KITTITAS COUNTY COMMUNITY DEVELOPMENT SERVICES

RE: Rosenberry Boundary Line Adjustment (BL-22-00017) – Transmittal of Comments and Request for Additional Information

Parcel# 959264	Parcel# 144835	Parcel# 634835
Parcel# 081936	Parcel# 071936	Parcel# 154835

**ROSENBERRY/
ROCKING R RANCH**

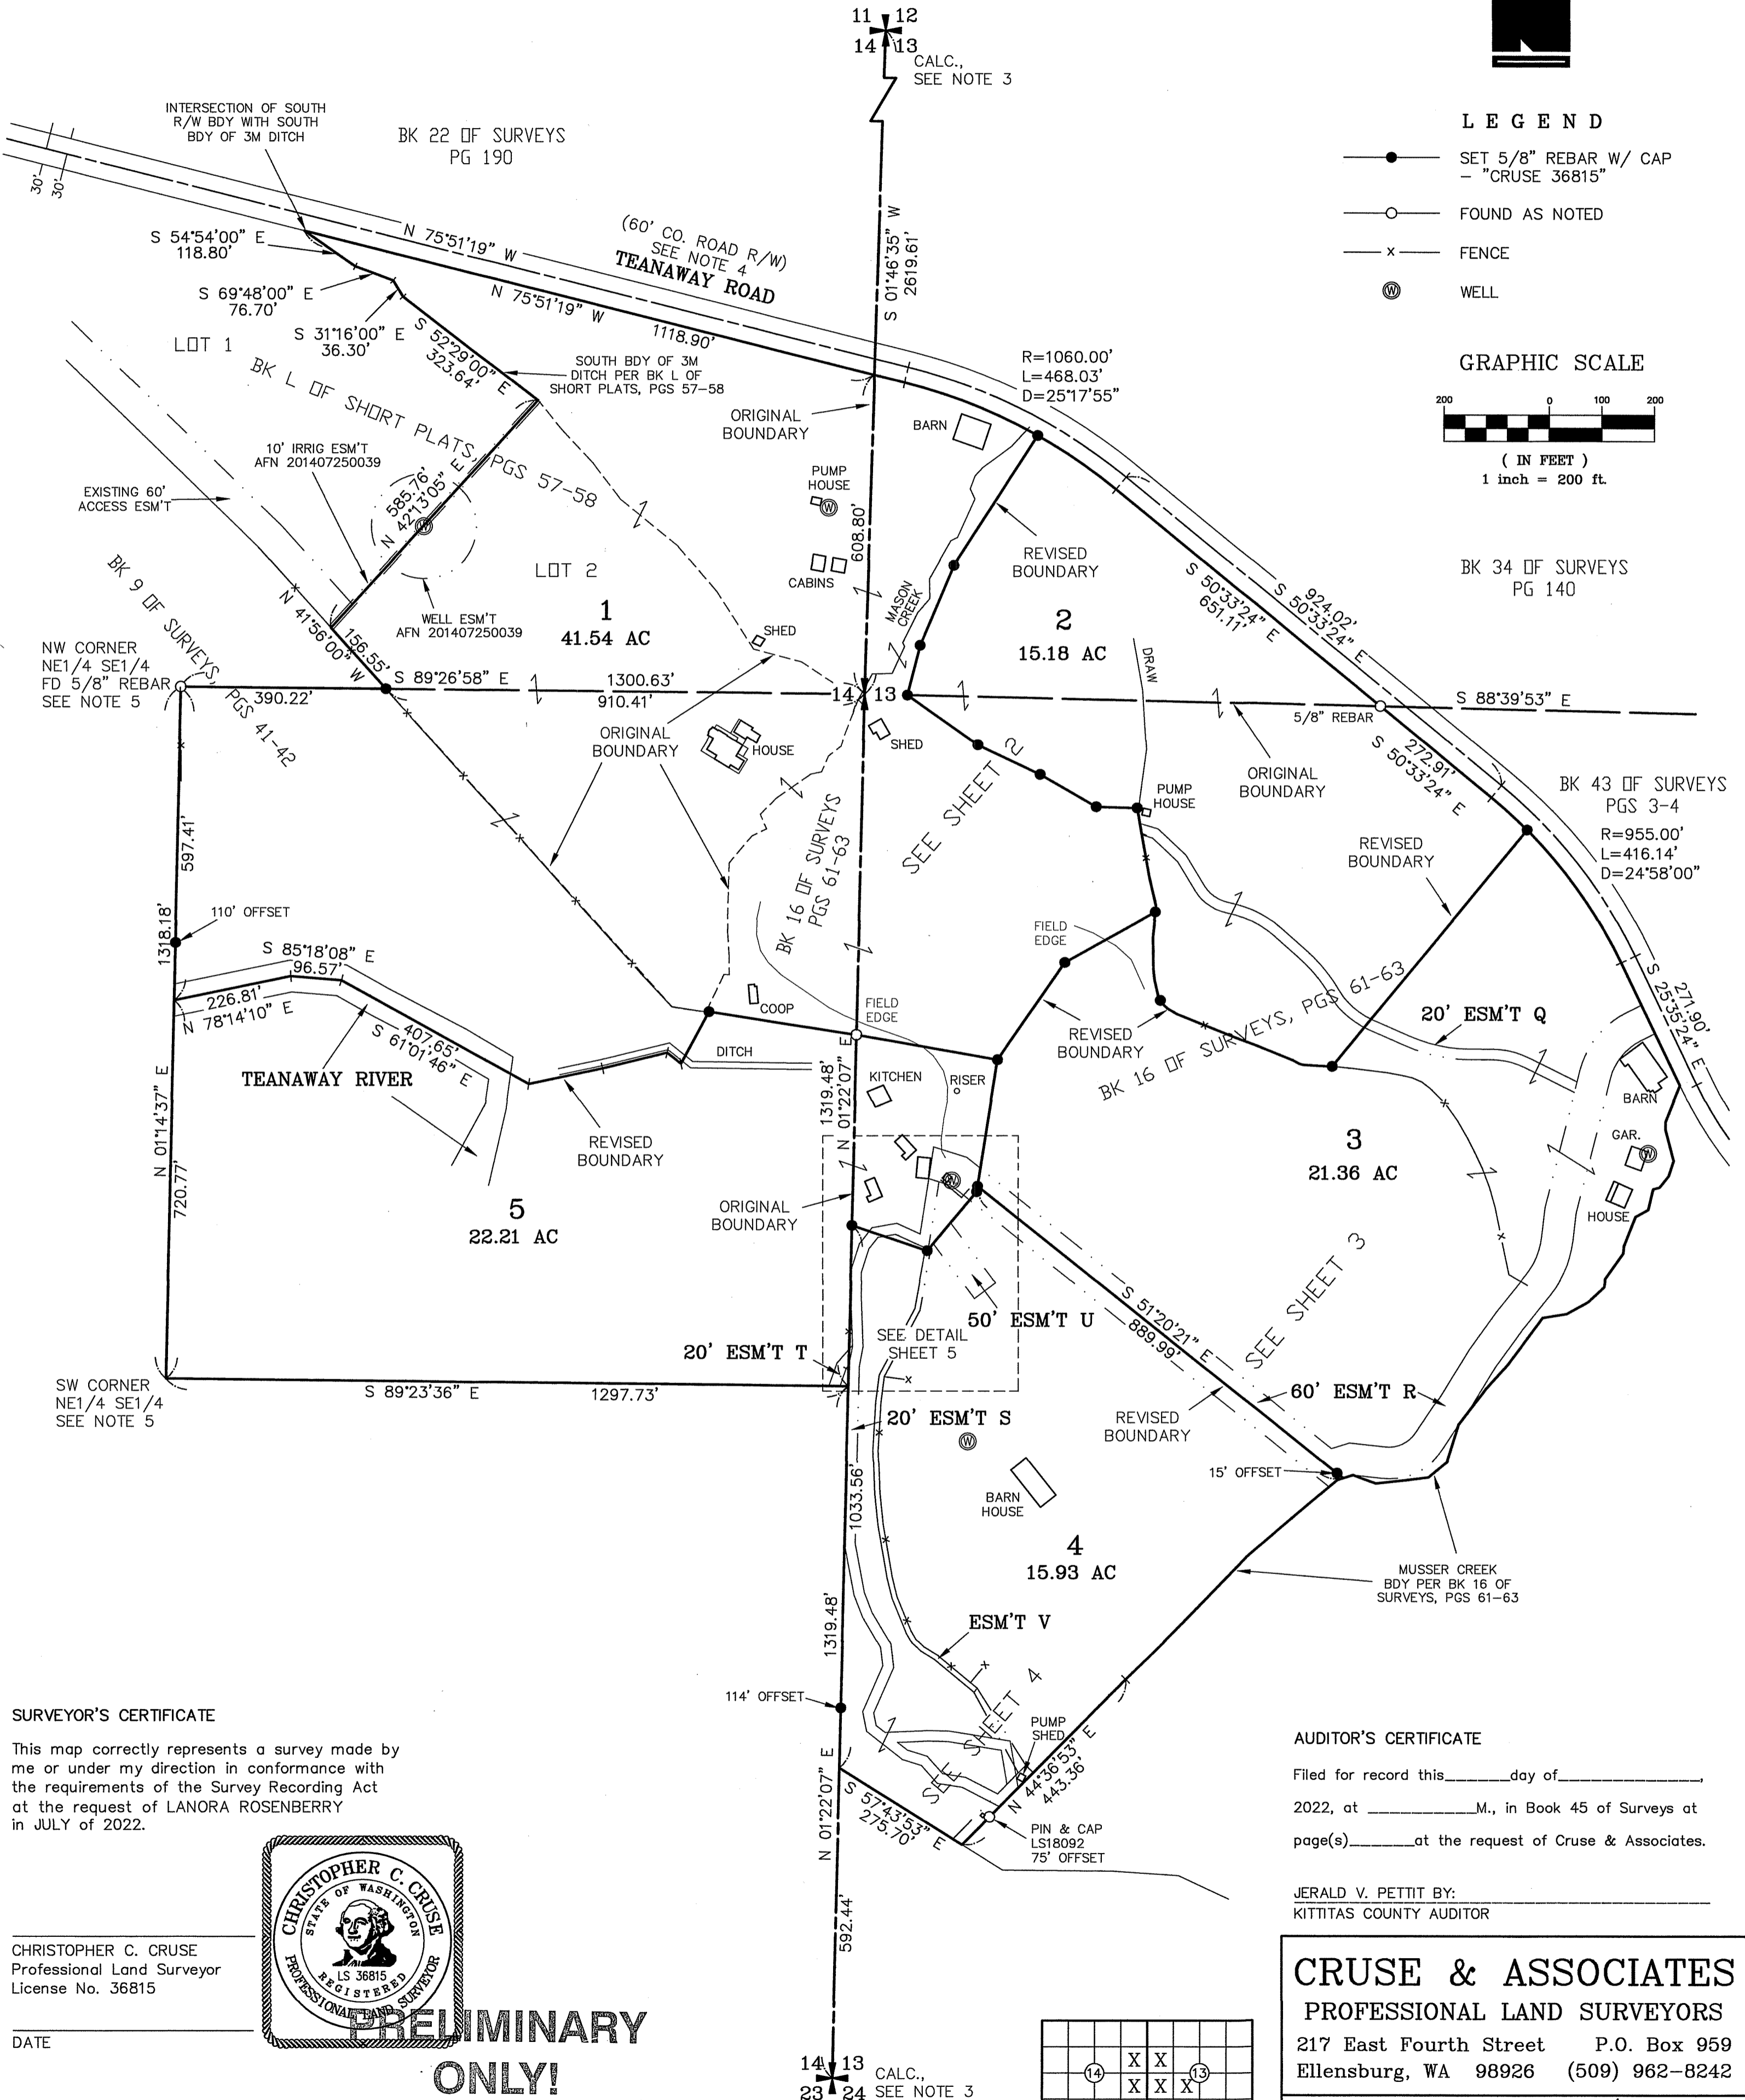
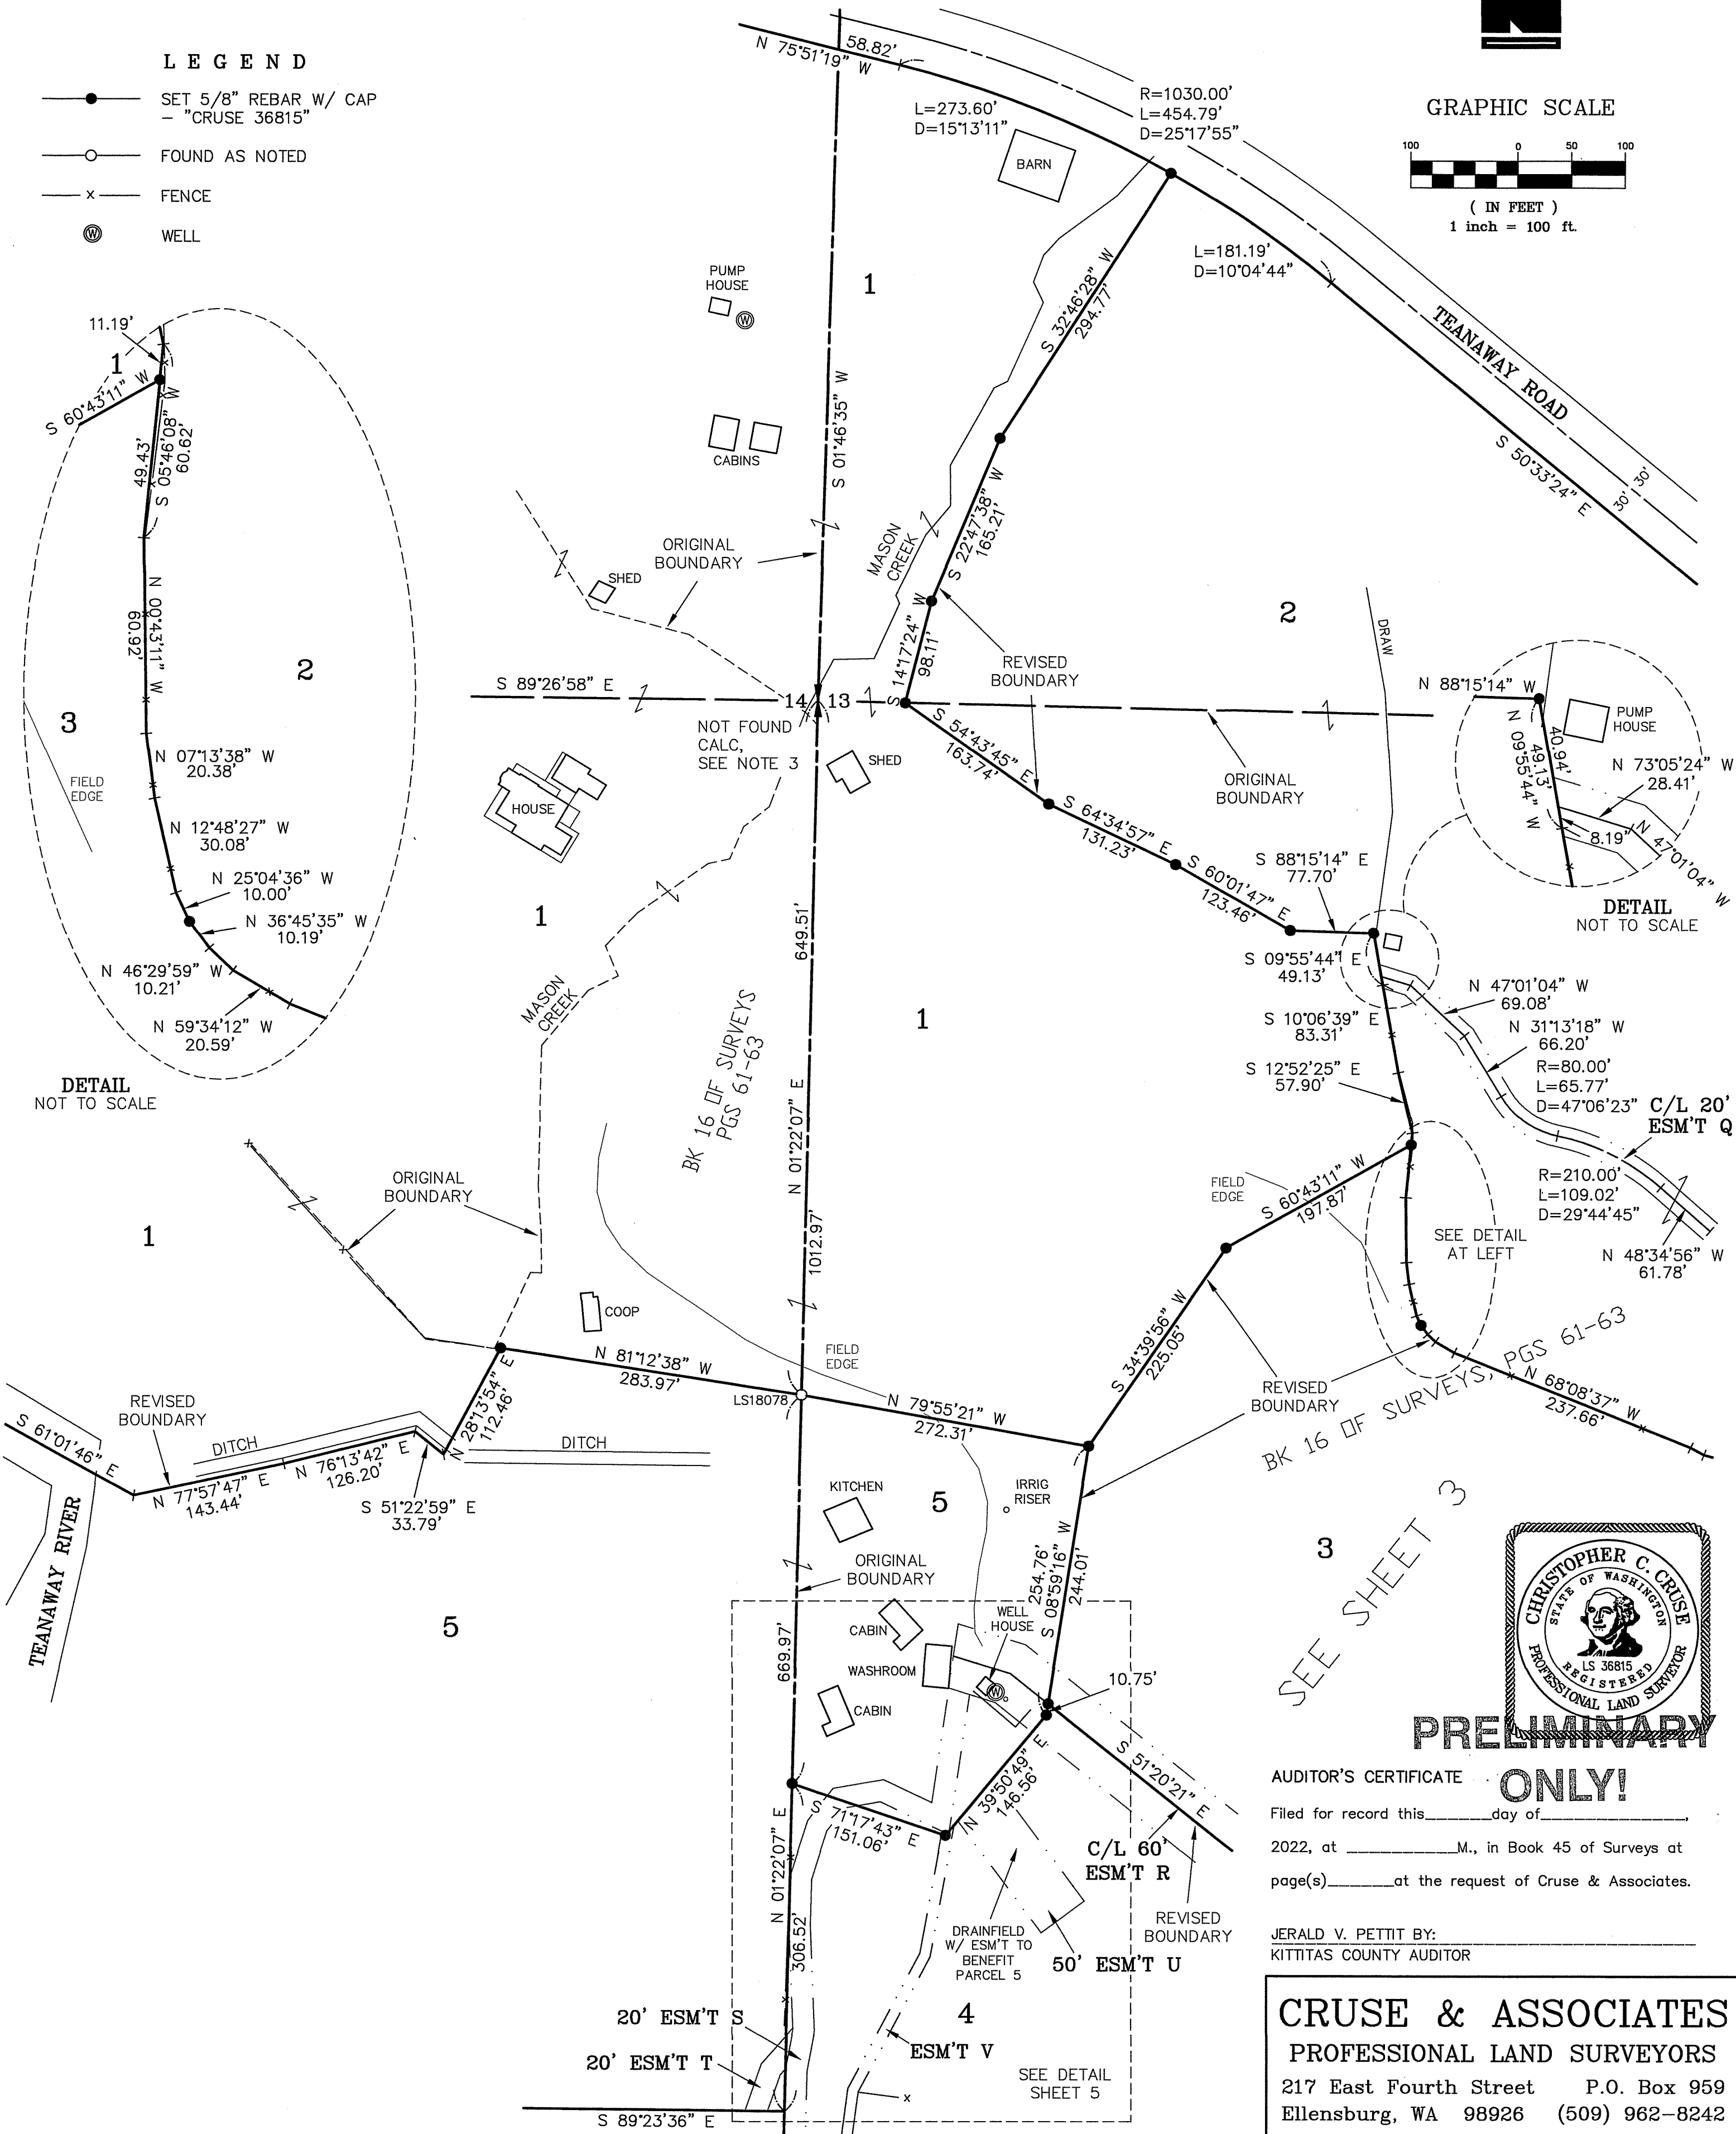
1. Provide the distance from the existing well to the property line on the new proposed property lines of parcel 5
2. Provide the distance from the septic tanks and drainfield from the proposed property line between parcel 4 and parcel 5.
3. A **preliminary survey** displaying legal descriptions, the new acreage and lot dimensions of each parcel must be submitted to our office for preliminary review (see Public Works' comments for requirement details).
4. Full year's taxes need to be paid for all tax parcel numbers per requirement of the Kittitas County Treasurer's Office. Please contact this office when this is accomplished as the Treasurer's office will not be aware of your pending application. No paperwork or receipt is required; just a phone call or an email will suffice.
5. Please refer to the enclosed comments from Kittitas County Public Works for further requirements.
